Our Case Number: ACP-323972-25

Re: Public realm and community infrastructure project on lands in Ardee, Co. Louth
Ardee, Co. Louth

Re: Notification under Section 175 of the Planning and Development Act 2001 as amended.

Re: Public Realm and Community Infrastructure Project on lands in Ardee, County Louth

Native wildflower
& grass planting

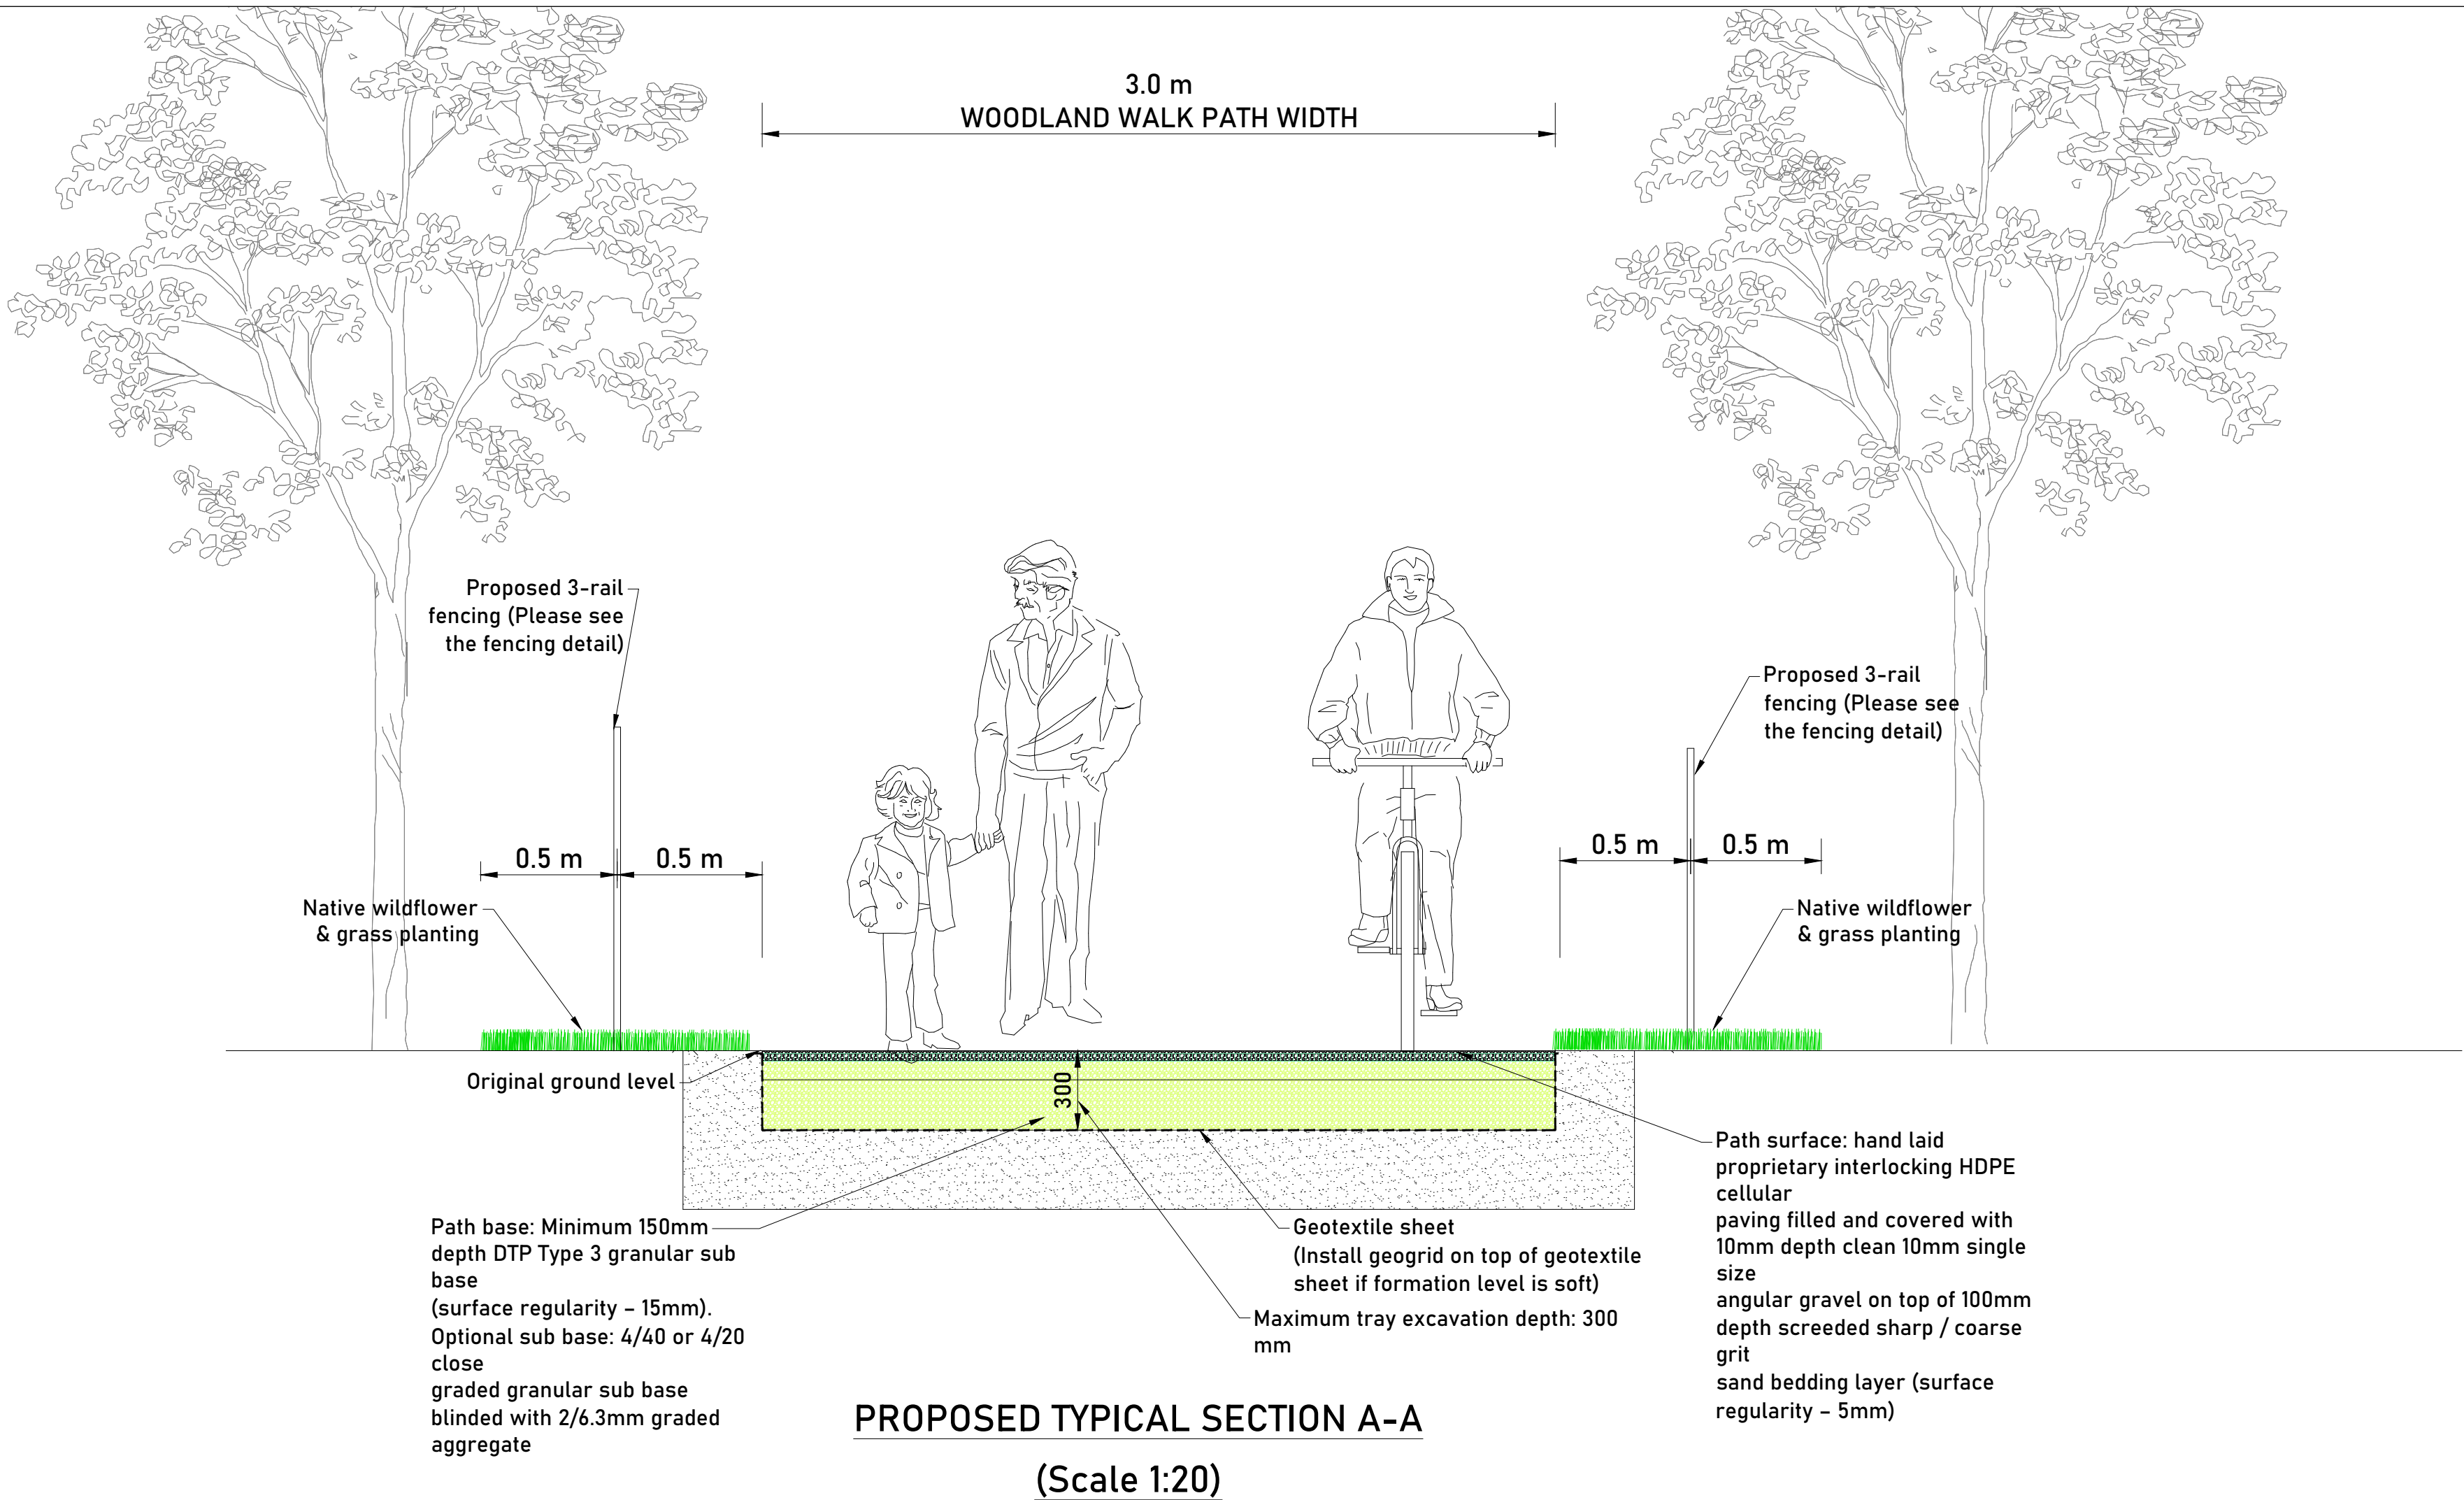
It is noted that the proposed development is located within the historic town of Ardee Recorded Monument historic town of Ardee (LH017-101) and that the proposed woodland walk is located along the line of the Town's Defences Recorded Monument LH017-101001-: Town defences both of which are subject to statutory protection in the Record of Monuments and Places, established under Section 12 of the National Monuments (Amendment) Act 1994. Given the extent and location of the proposed development it could impact on subsurface archaeological remains.

1. All ground works associated with the proposed development shall be monitored under licence by a suitably qualified Archaeologist. The Archaeologist shall also carry out a programme of Test Excavations prior to any groundworks along the line of the proposed woodland walk at locations chosen by the Archaeologist in relation to Recorded Monument LH017-101001- : Town defences (licensed under the National Monuments Acts 1930-2004), having consulted the site drawings and the National Monuments Service.
